# CITY OF ALBUQUERQUE

**Re: Montage Units Charter School Neighborhood Impact Assessment (NIA) Memo**  
Dated June 15, 2021 (R16D099)  
Received June 15, 2021  
Initial review comments from CABQ Planning Transportation

The subject Neighborhood Impact Assessment for the Montage Units Charter School. dated June 15, 2021 received on June 15, 2021 has been reviewed by the Transportation Development Section. The following are questions and comments that should be addressed and corrected in the next submittal.

Site Plan

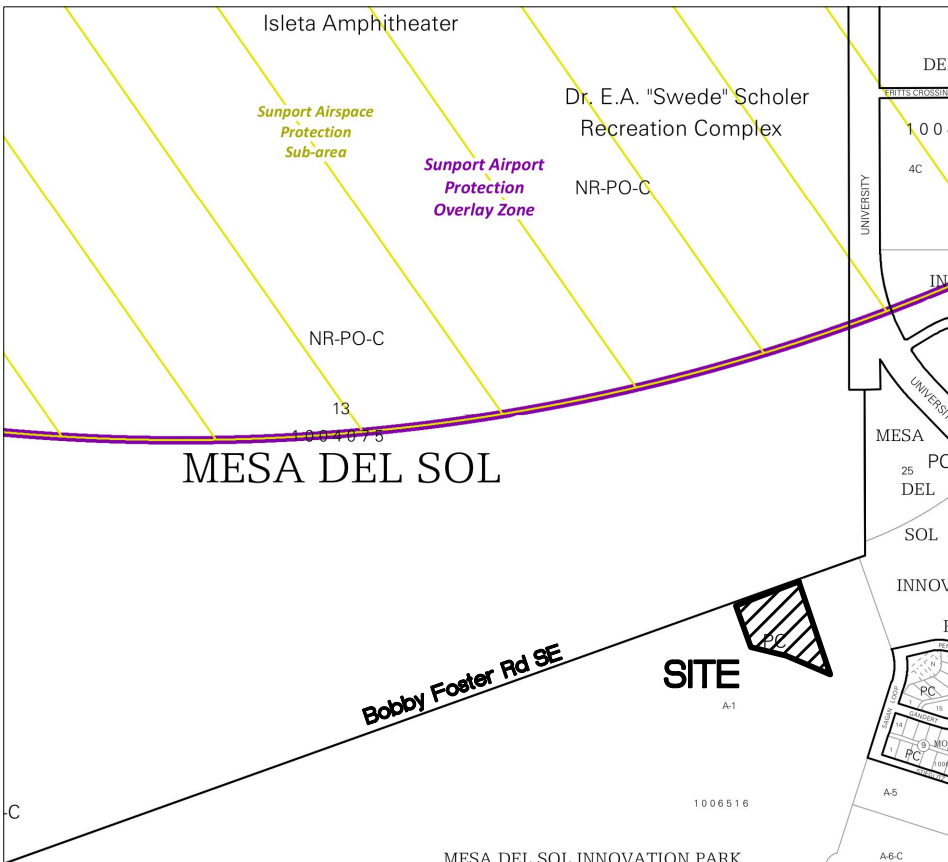
- How many buses will be dropping off and picking up at the school?
  - What is the expected queue length for the buses worse case?
  - Show where the drop off location is and the bus when stopped at the drop-off.

- The street in front of the school is one-way. Will the waiting vehicle be blocking the street?
- EVALUATION OF REASONABLE ALTERNATIVES; Additional mitigation for noise and air quality: Develop and implement a No-Idle policy for waiting vehicles. Encourage the use of carpooling. These policies/practices need to be accepted by the school, abided by the parents and monitored for compliance

- Label the street immediately south of the school property.
- Correct the spelling to Diebenkorn throughout the memo.
- Provide a label for Figure 2. Figure 2 is noted in the title block but not as the figure designation in the memo.

Figure 5 – ABQ Ride System Map

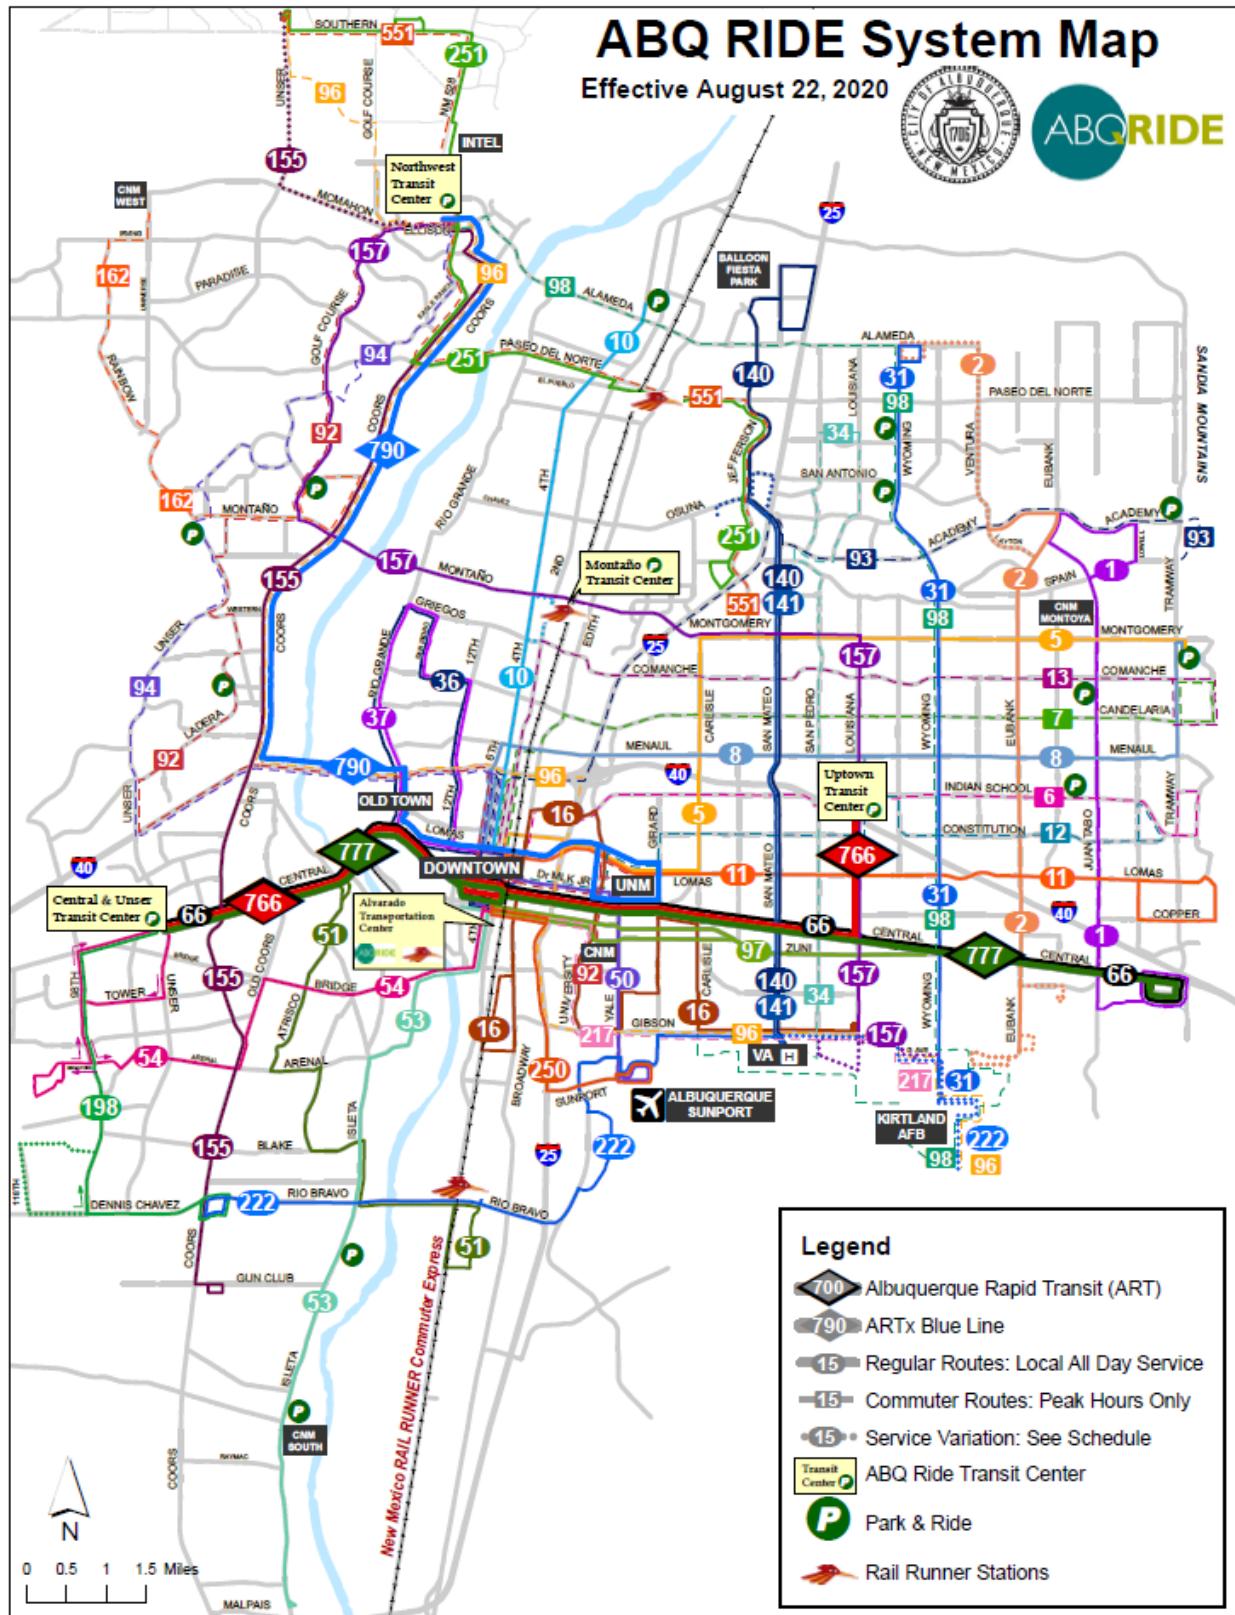
- 3.2.2 ABQ Ride:
  - Is ABQ Ride a viable option for the students if a route is operational.
- Is there evidence that the internal capture is valid for the nearby residents. Where do the student live?

Figure 6 – 0.25 Mile Radius Site Map

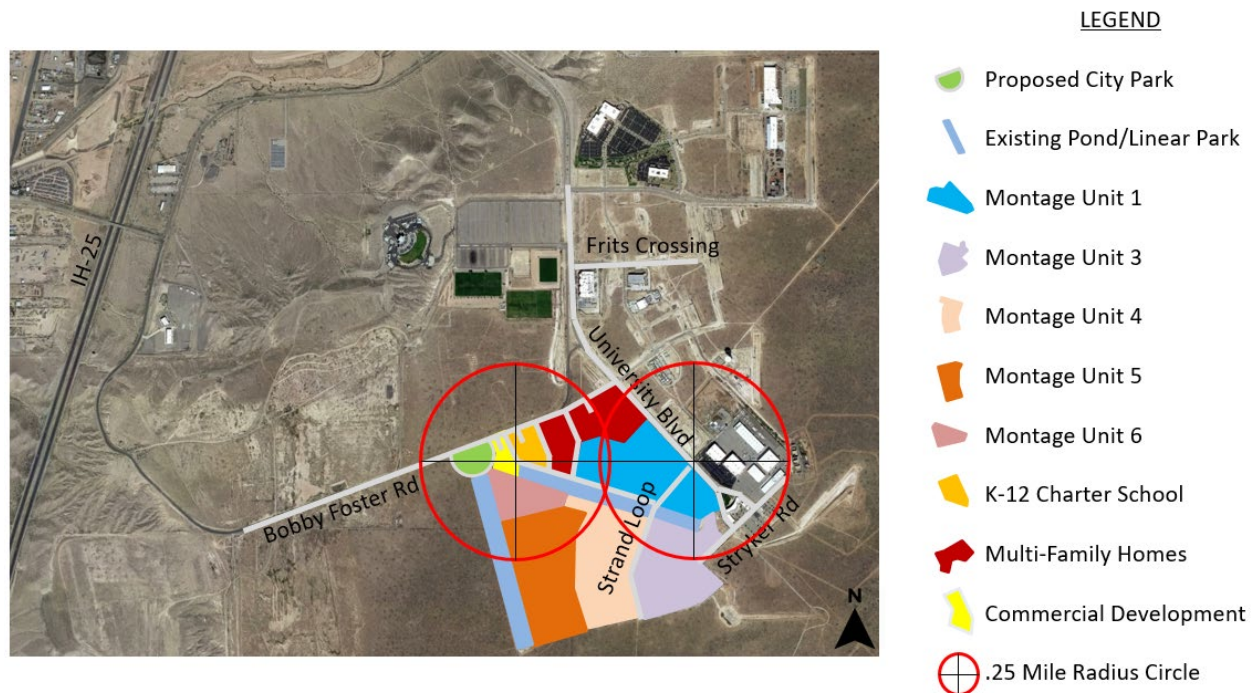
- This is a Charter School. Is there any evidence that the internal capture is valid for the nearby residents? Where do the student live? This indicates that all of the student population is living at Mesa del Sol. That is not reasonable for a Charter School.

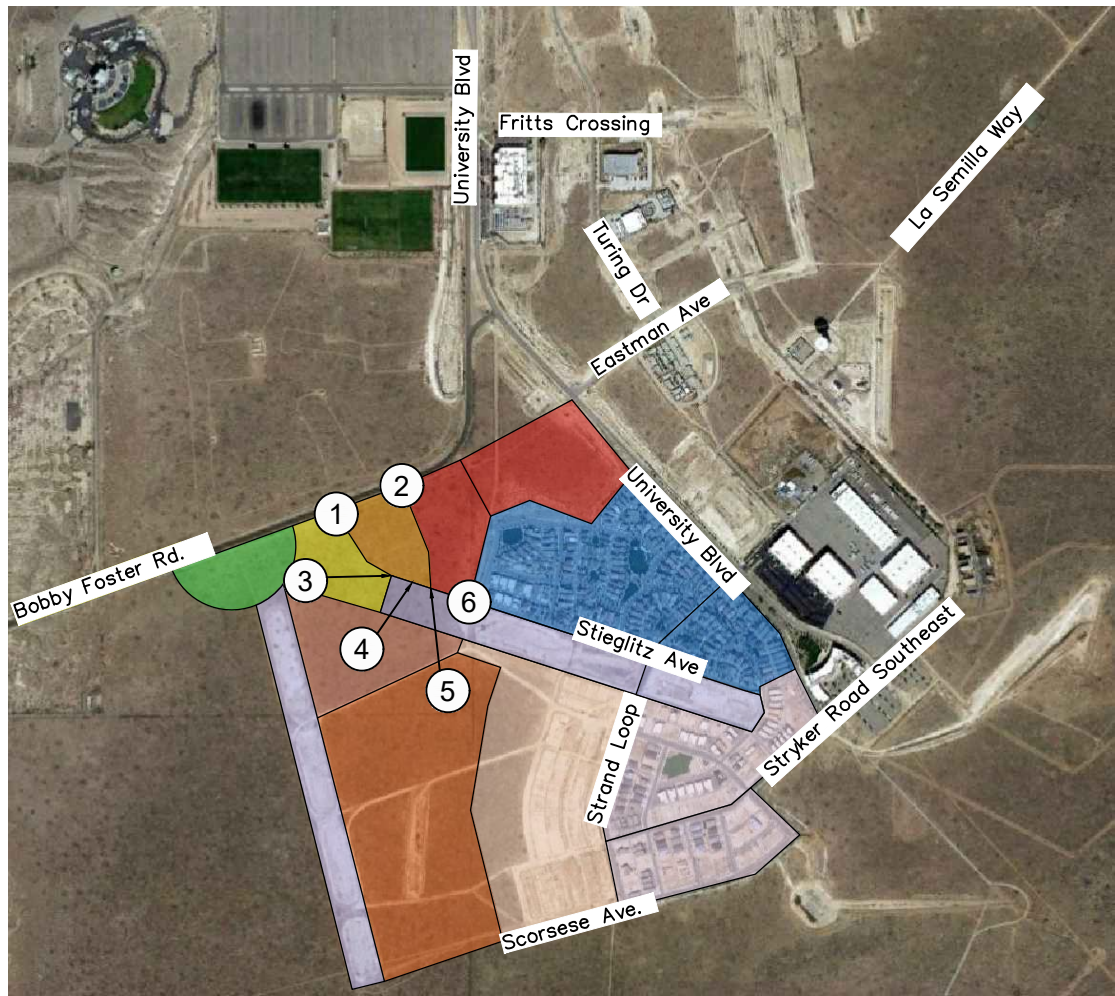
Correct the following sentence removing the word “under”. Traffic generated by the developments **under** had to be distributed and assigned to the study area intersections so that the analyses could be conducted.

- 4.4.1 Charter School; For the charter school development trips, it was assumed that the remaining adjusted trips will be proportionate to the number of residential units outside of the 0.25 mile radius.
